# CITY OF ALBUQUERQUE

**RE: Lot 13 Block 10 SAD 228  
Volcano Cliffs Subdivision Unit 22  
6300 Petirrojo Rd. NW  
Grading and Drainage Plan  
Engineers Stamp Date 3/22/2017 (D10D003F13A)  
Pad Certification Date 5/10/2021  
CO Certification Dated: 5/11/2021**

ENGINEER'S SEAL	6300 PERIRROJO	DRAWN BY WCUJ
DAVID SOULE NEW MEXICO REGISTERED PROFESSIONAL ENGINEER 3/22/17	GRADING AND DRAINAGE PLAN	DATE 3-20-17
		21721-LAYOUT-3-20-17
		SHEET #
		JOB #
		21721

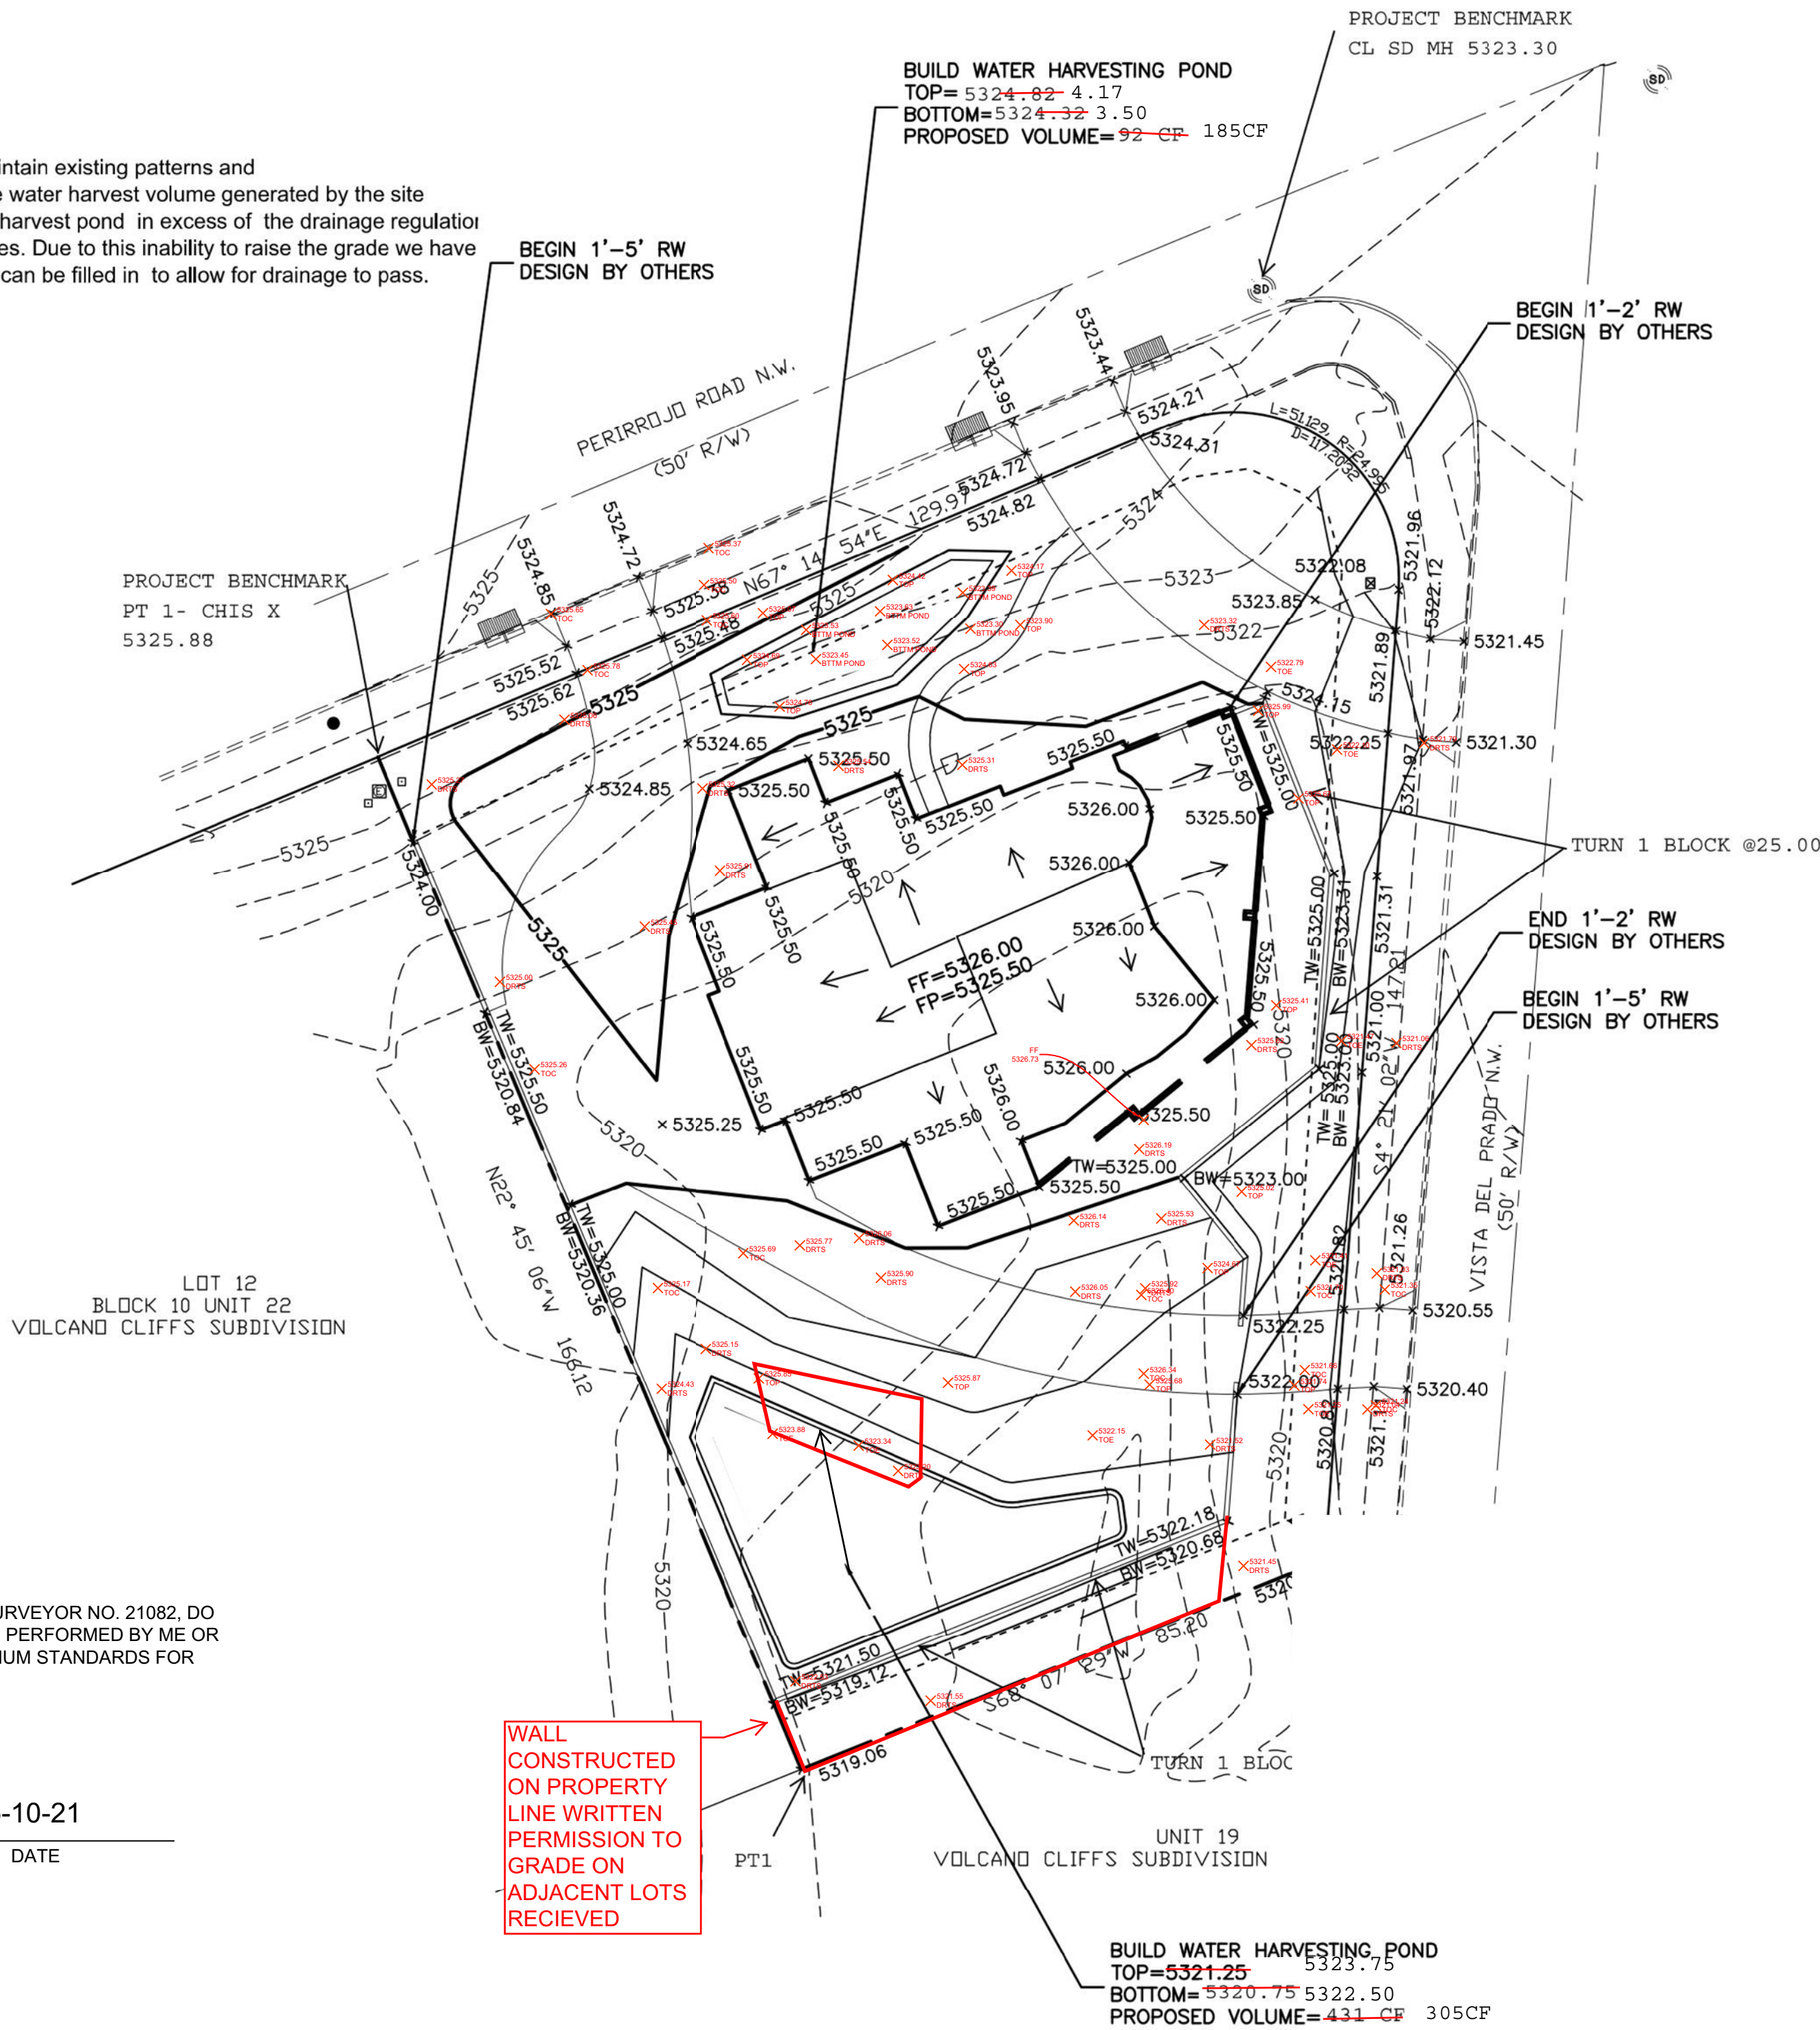
- Site needs protection from erosion.
